**Consultation Response from KC,
Conservation & Design**

2023/90719 land rear of, 8, Longwood Road, Paddock, Huddersfield, HD3 4EU

Listed Building Consent for conversion of storage barn to create two apartments

Date Responded: 28.11.2023

South elevation (1:100).

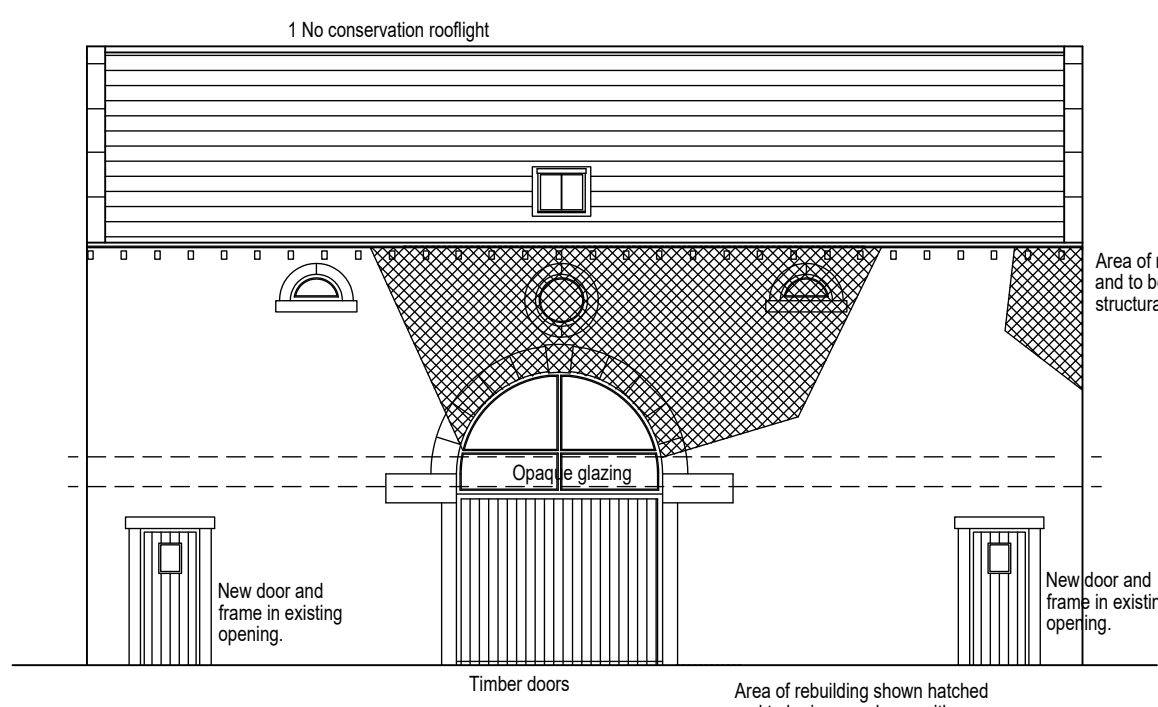
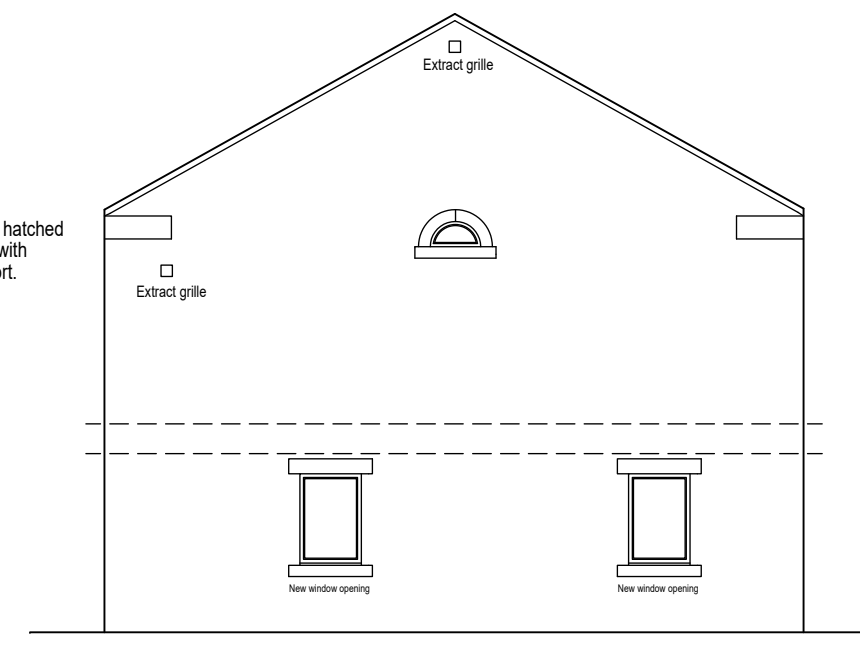
We are not convinced by the proposed door to the main barn doorways on the northern and southern elevations. The details on the plans state them as being Auto garage doors. We require further detail in this regard to satisfy our concerns. We consider that a pair of central opening doors timber doors would be the most appropriate option and would be entirely in character with the building. This would however be subject to detail. Details for the doors should be submitted at a scale of 1:10 – 1:20.

We do have some concerns in relation to the proposed insertion of the roof lights as these will create intrusive features to the roof line which will be visible from several site lines. We do however accept there needs to be some allowance for natural light. We would however query if the size of the roof lights could be reduced slightly as some form of mitigation.

North Elevation (1:100).

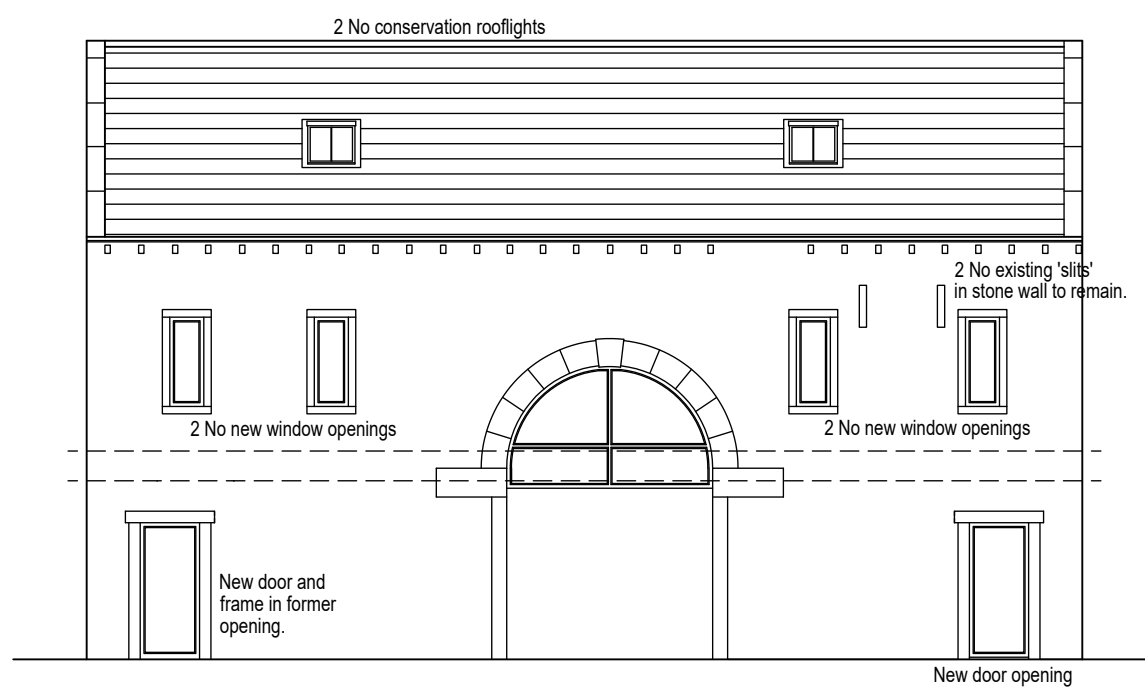
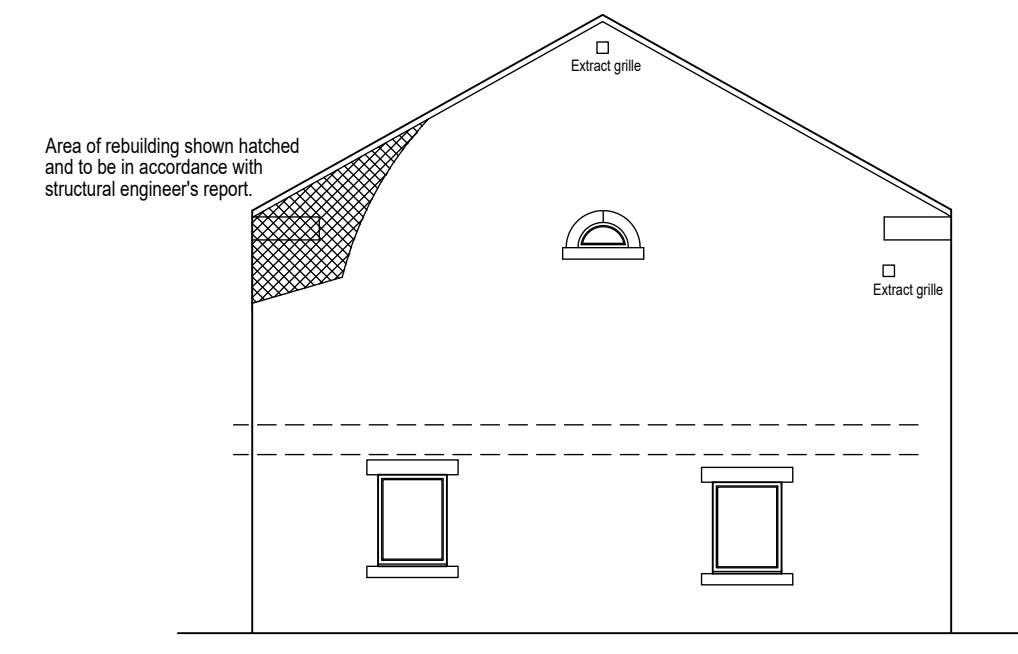
We have greater concerns with the proposed new window openings to the northern elevation. To the ground floor, we are satisfied with the proposed re-opening of the existing doorway and matching door to the right-hand side of the elevation. We are however not convinced by the proposed new window openings to the first floor. We consider the new openings while accepting the rationale behind them, do not fit with the character of the building. We consider that they need to be of uniform size and be reduced in width to create more of an arrow slit-style window opening. The sketch below shows the proposed amendment to the first-floor windows. This would allow for the natural light, but reduce the impact on the building.

Section

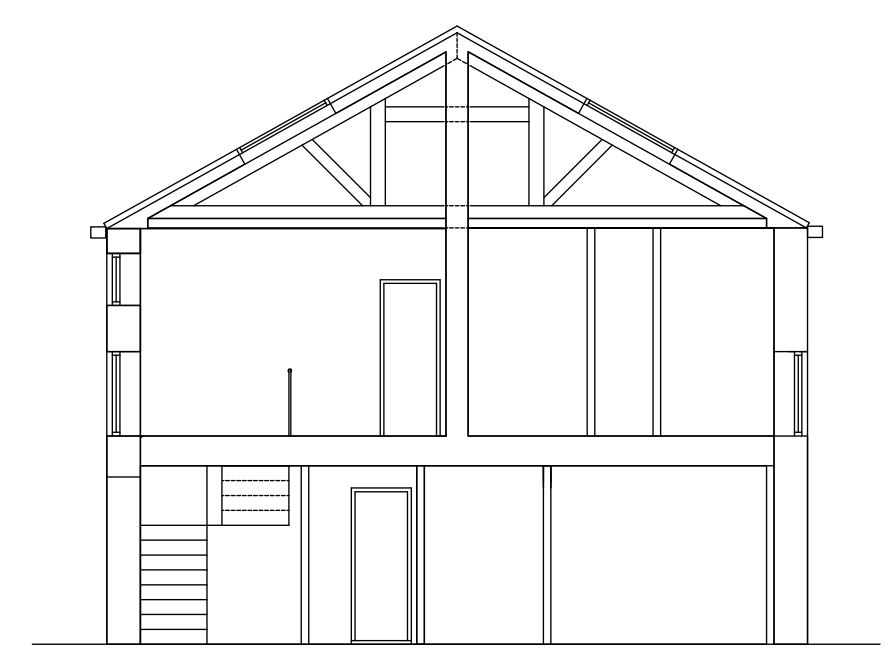
The roof is noted as being in a poor state of repair and in need of repair/ replacement. While this is the case the timbers do form a part of the significance of the building and the historic timbers, purlins, rafters and trusses should be retained. We would not accept the loss of these details and the approach should be retention, with supporting timbers inserted where required.

Window/door jamb detail (1:20)

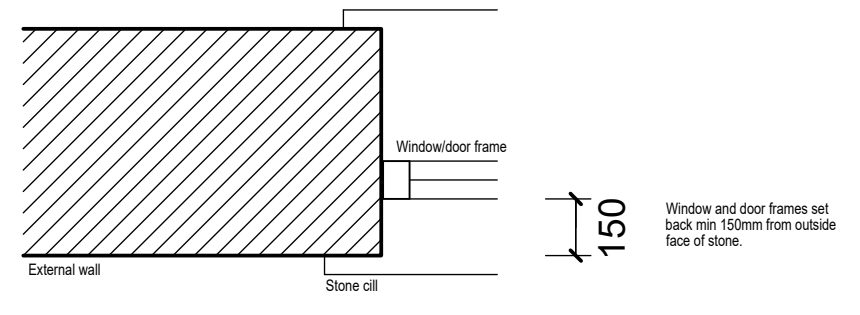
We are lacking joinery details for the windows and doors to the existing and new openings, and these should be provided at a scale of 1:10 – 1:20.
